Broadoak Farm, Linthwaite

ROAD SAFETY AUDIT - DESIGNERS RESPONSE

AJP Ref: 219-174

The report has been produced in response to the Stage 1/2 Road Safety Audit produced by Highways Associates (REF 2022/AJP/1590) to comment on the items raised in respect of the future use and safety of the proposed highways at the development of Broadoak Farm, Linthwaite.

TITLE: EXTERNAL WORKS PLAN (2 OF 4)

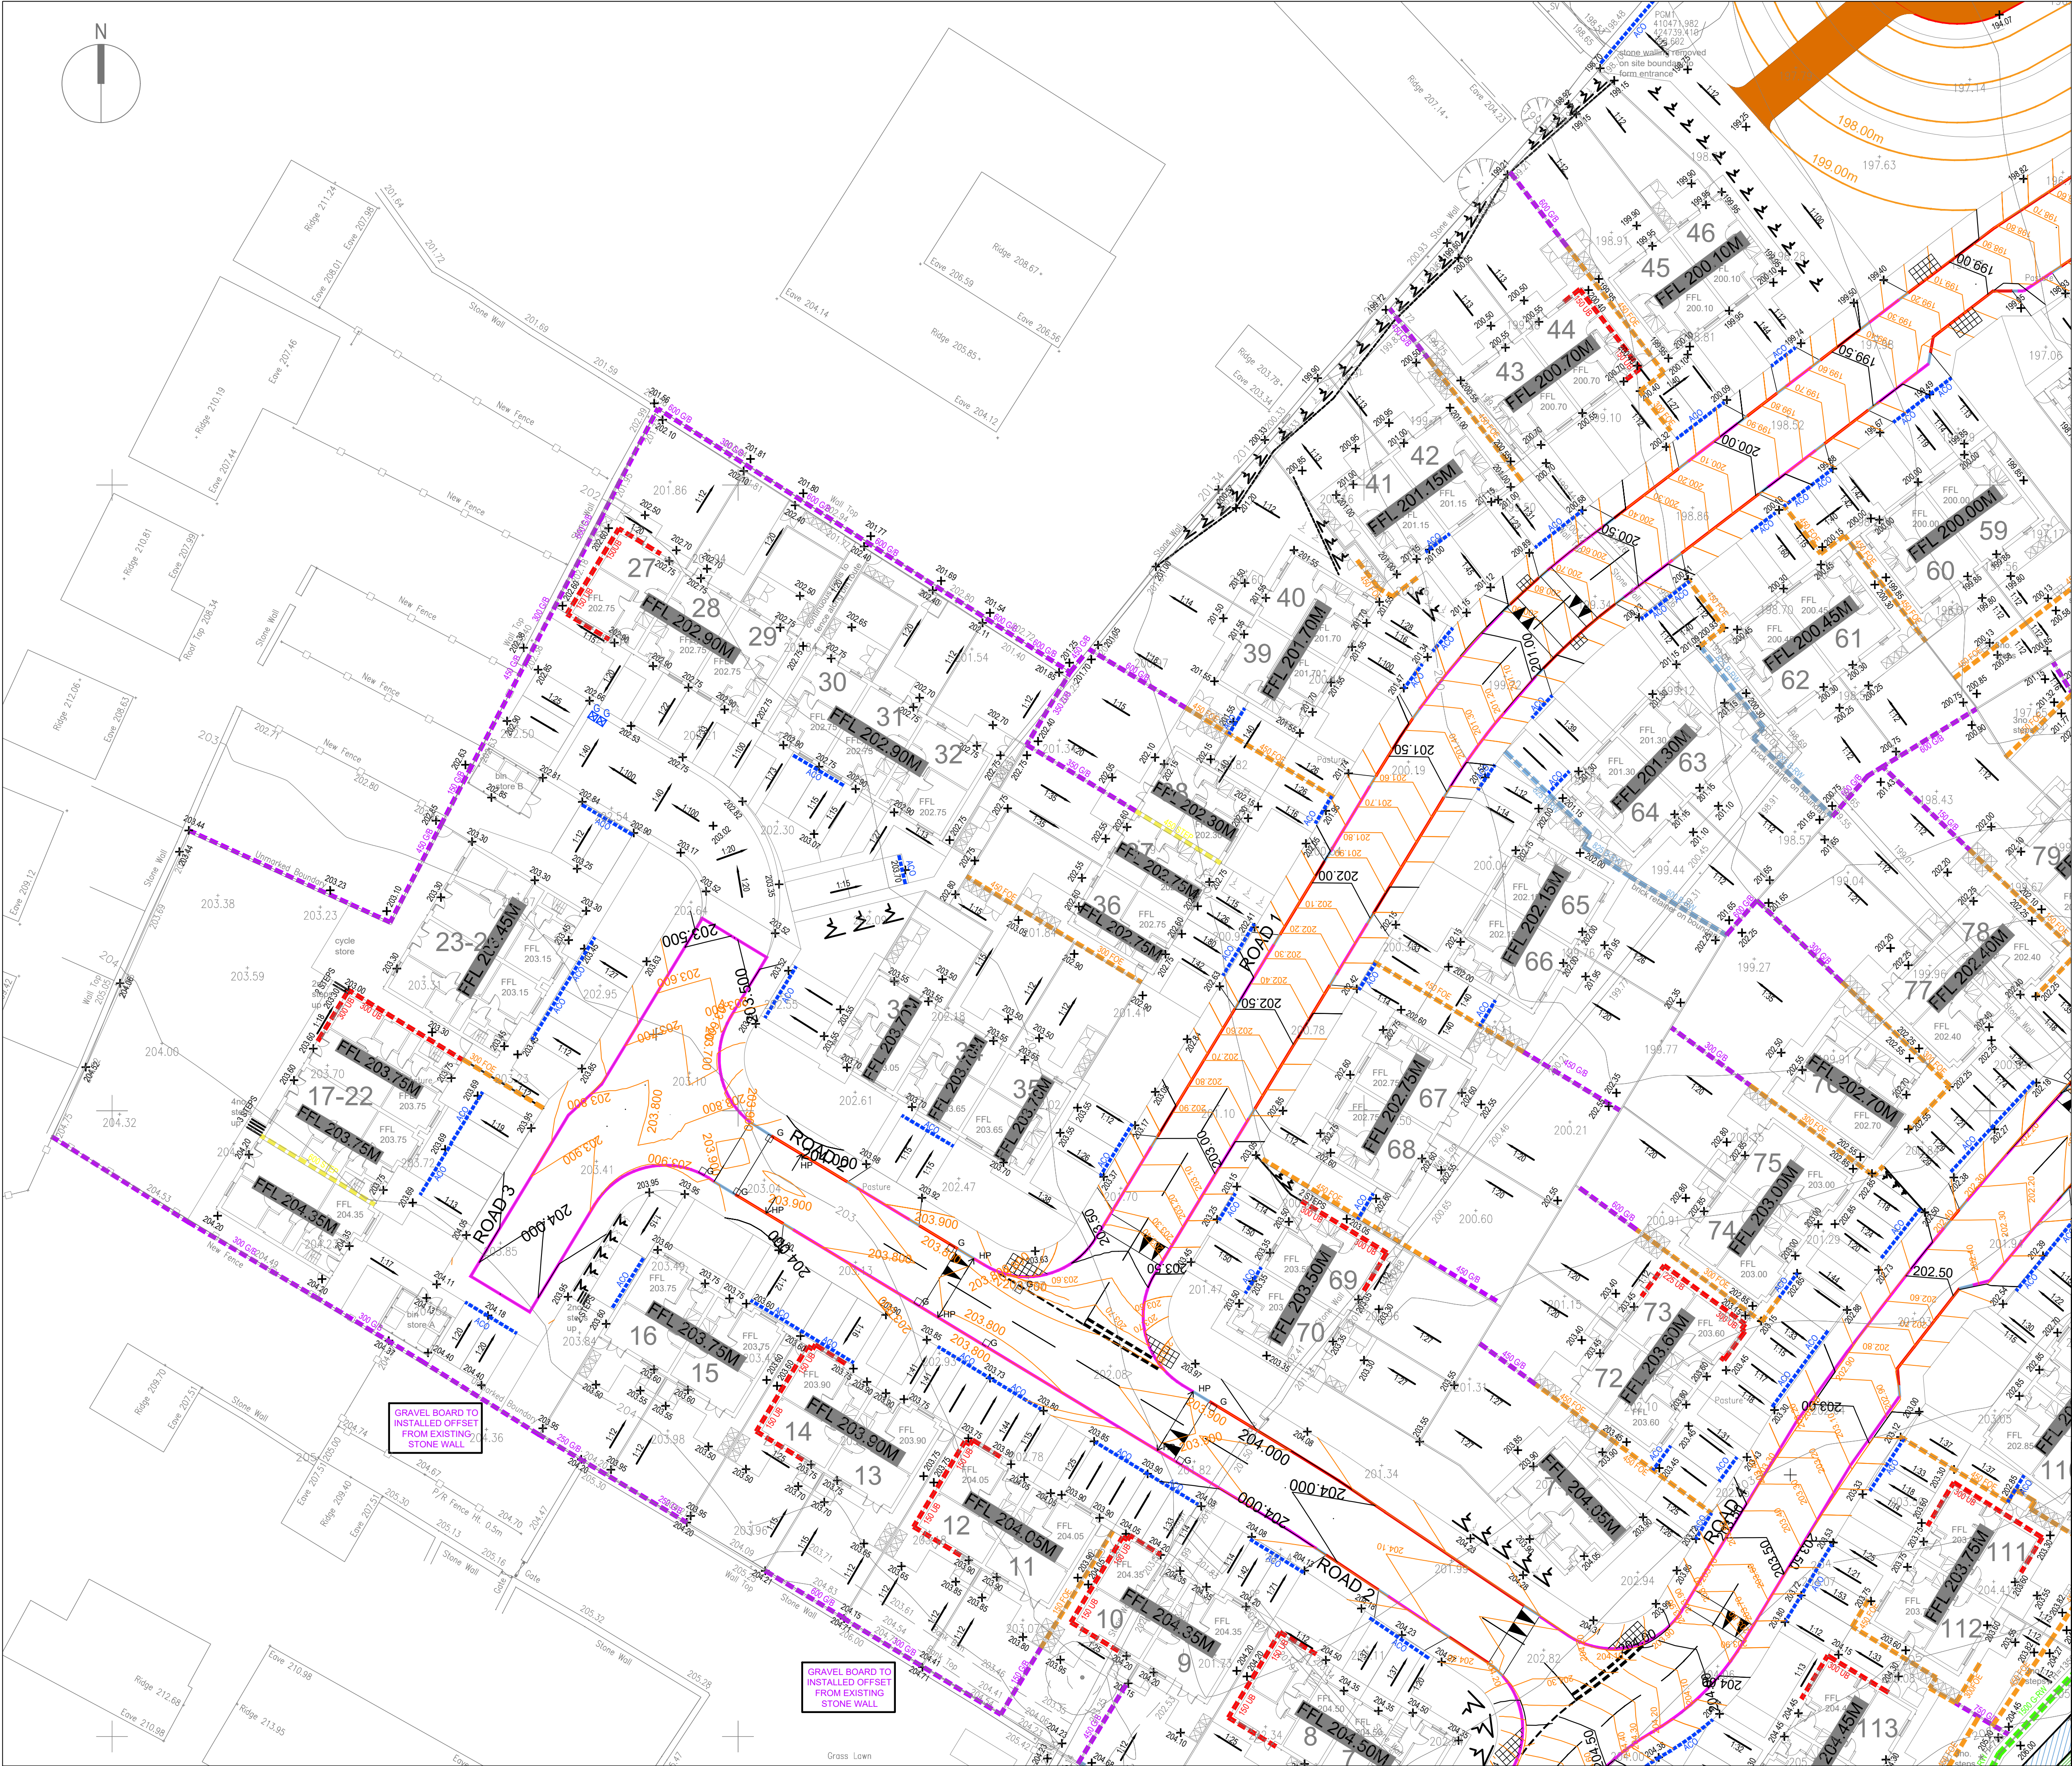
**LOCATION:** Road 2, outside Plot 10,11

**SUMMARY:** Vertical traffic calming measures could result in conflicts

The proposed junction table extends and terminates within the vehicular crossing alignments of the above plots. As such, concern is expressed that vehicles, particularly powered two wheelers could become destabilised by the transitional levels whilst manoeuvring potentially at speed resulting in loss of control conflict.

The termination of the junction tables should occur outside of any vehicular crossings.

Item rejected, the necessary traffic calming feature has been positioned optimally to avoid vehicular crossings and ensure effective traffic calming for safety.
